PREFERRED PROJECT REPORT
MP 10_0171

330 CHURCH STREET, PARRAMATTA

JULY 2012

SHADOW DIAGRAM - WINTER SOLSTICE (JUNE 21ST) 12.00PM
1:2000 @ A1

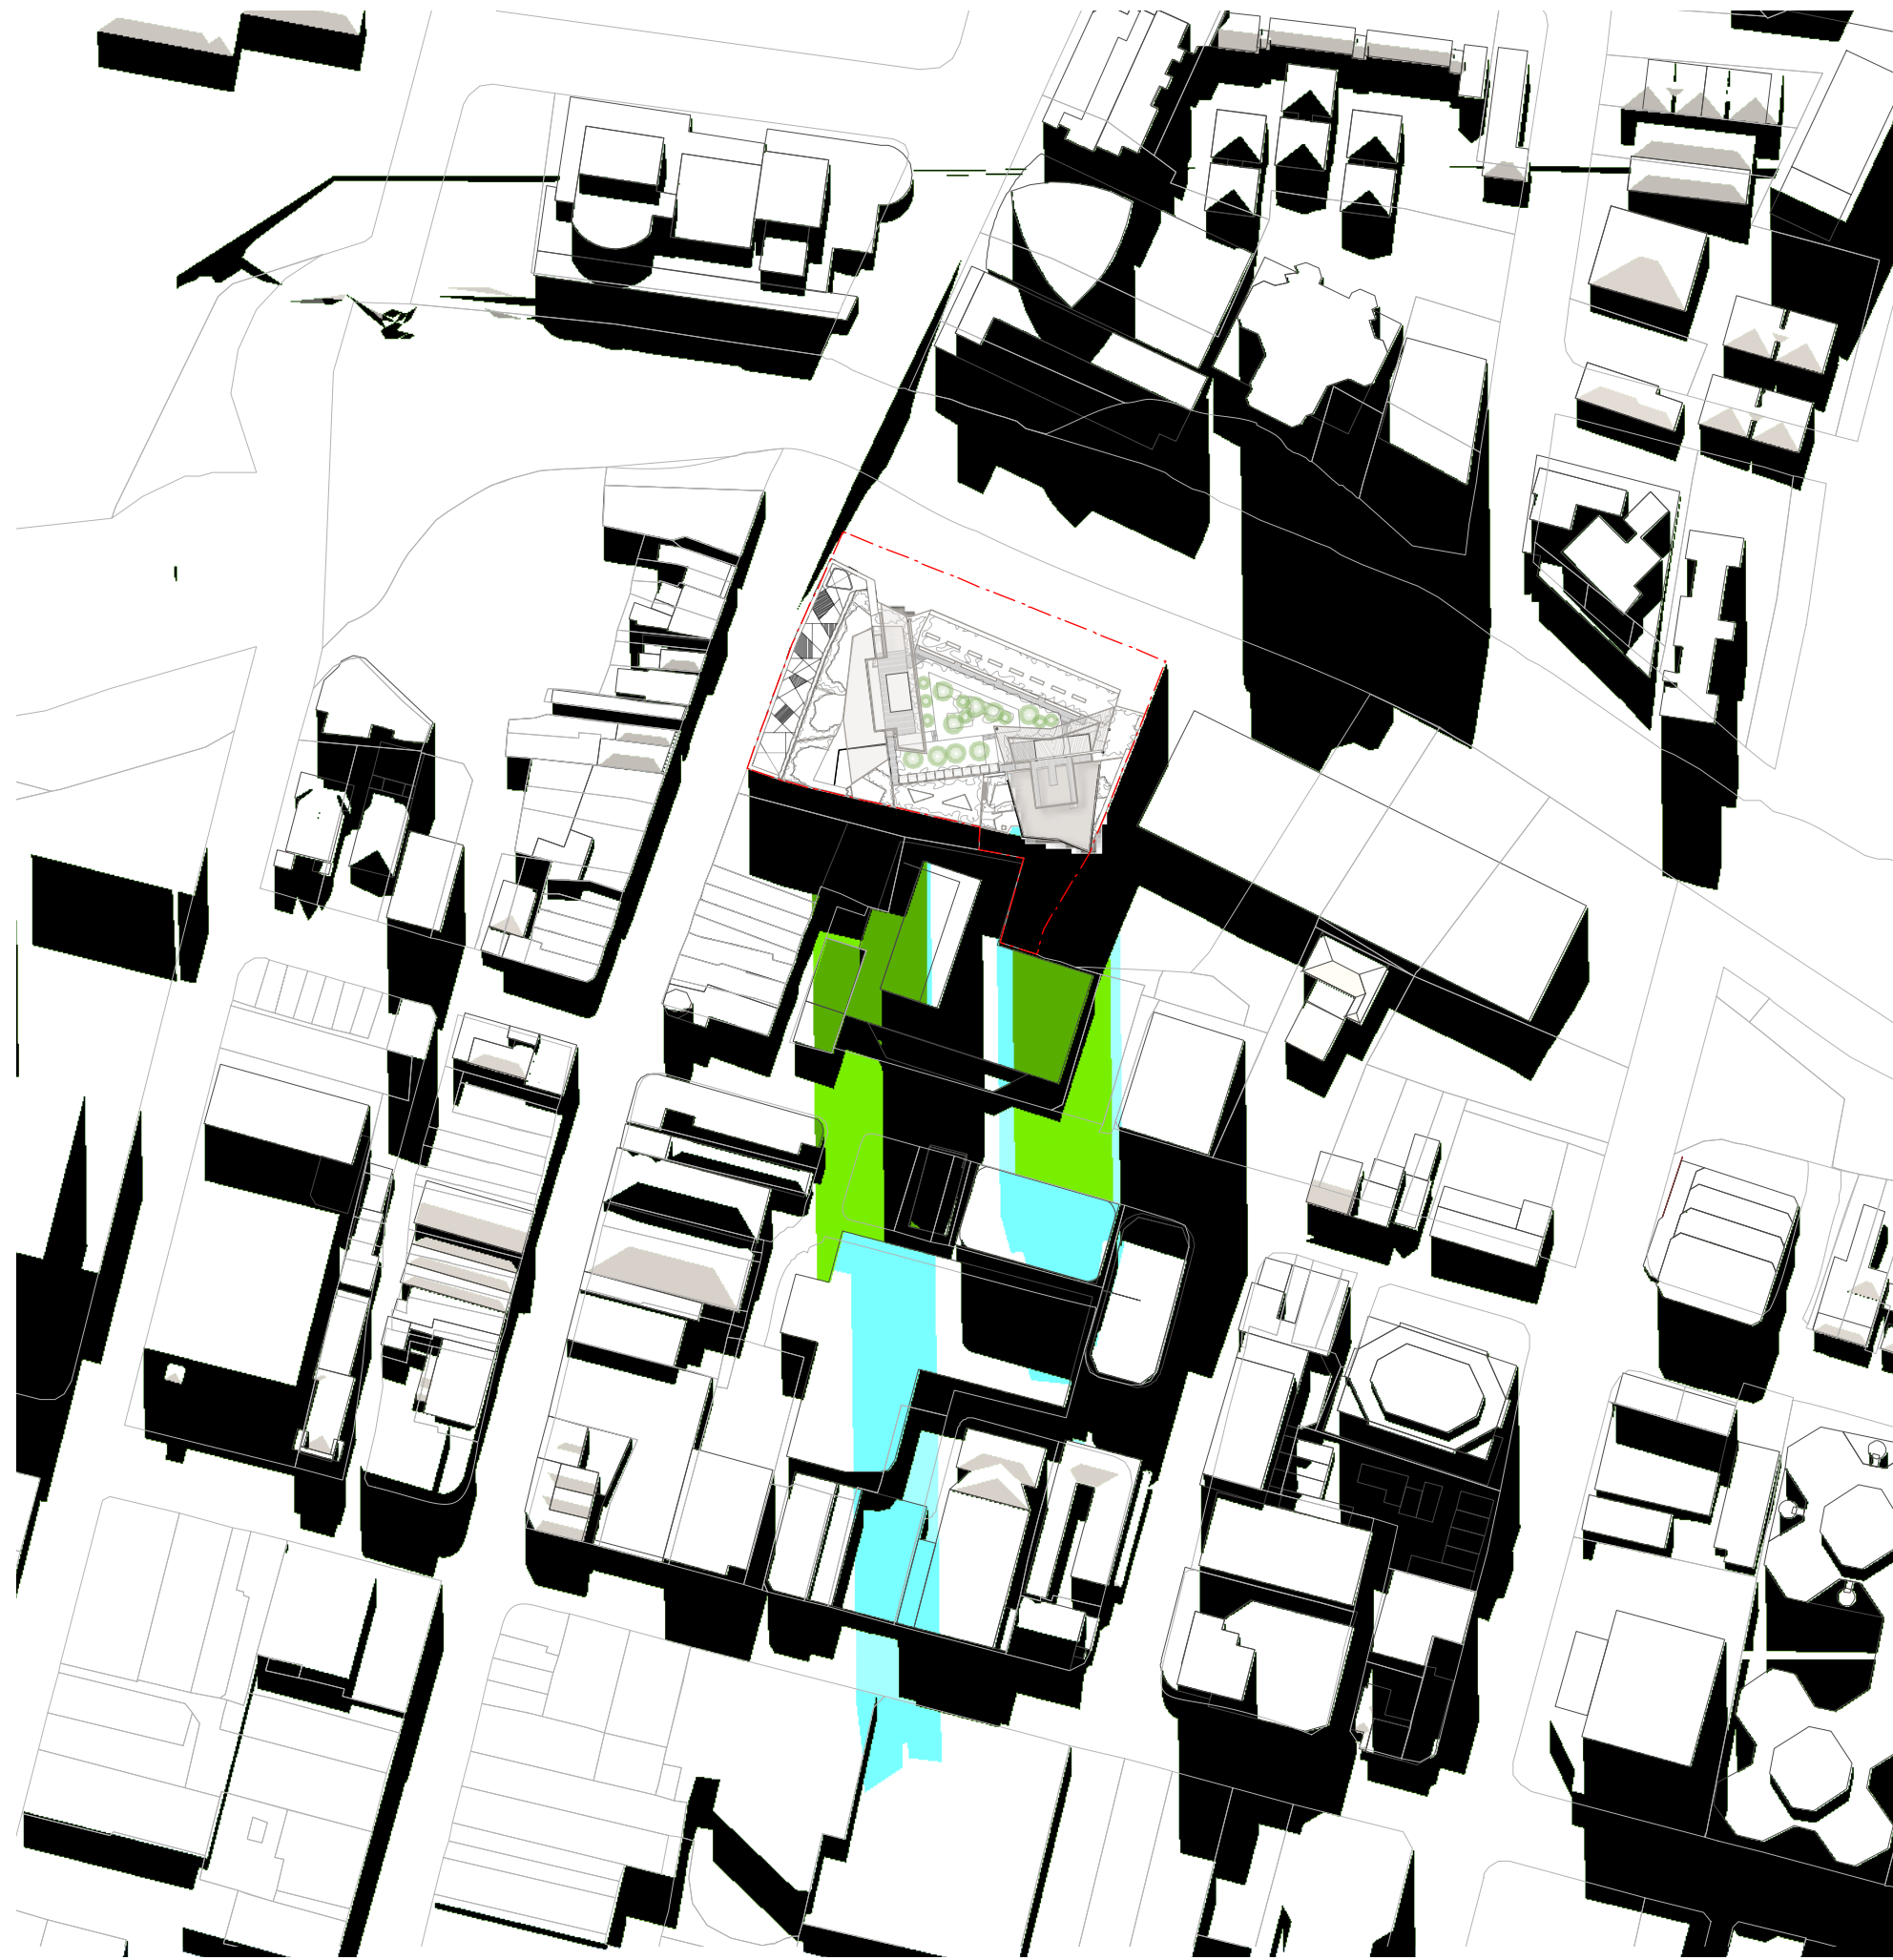
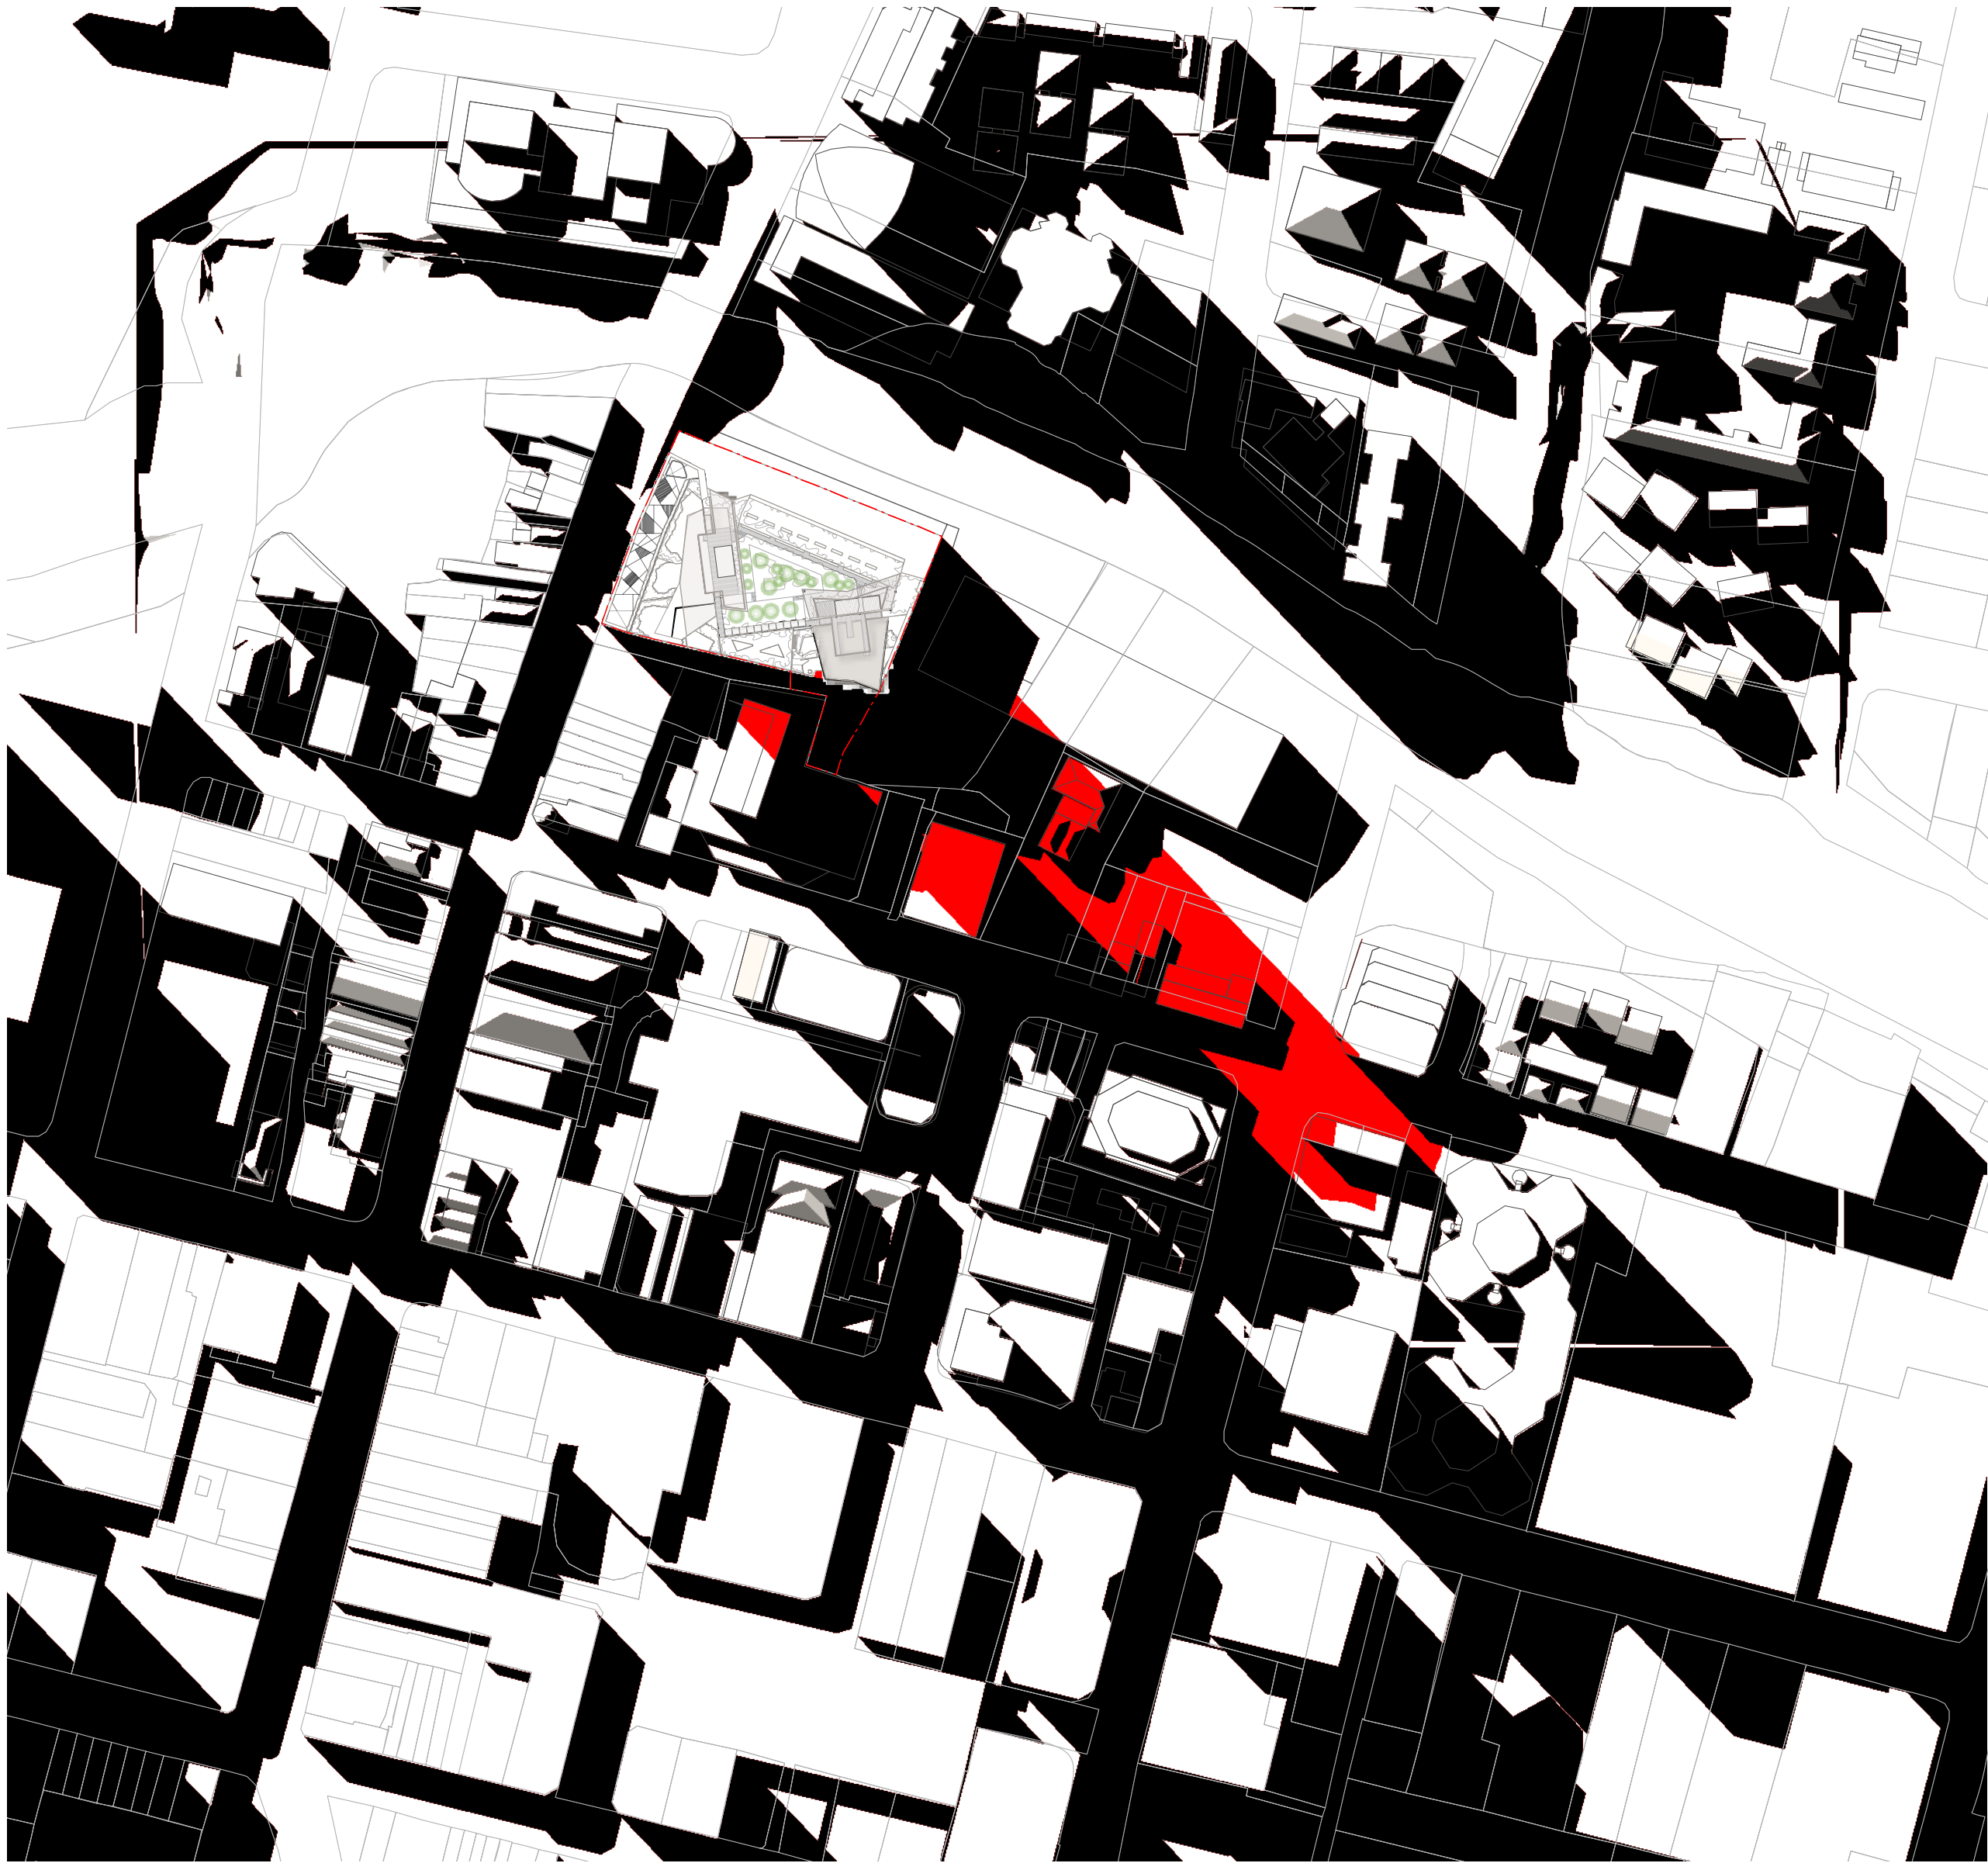
Shadow Diagrams

The architectural plans have been amended to include shadow diagrams providing a comparison between the existing building, a compliant development (built to the current height maximum and incorporating the setbacks specified in the Riverbank Site Controls) and the proposed development. This is now shown on plan A500 and A501. The amended architectural plans are at Annexure 3.
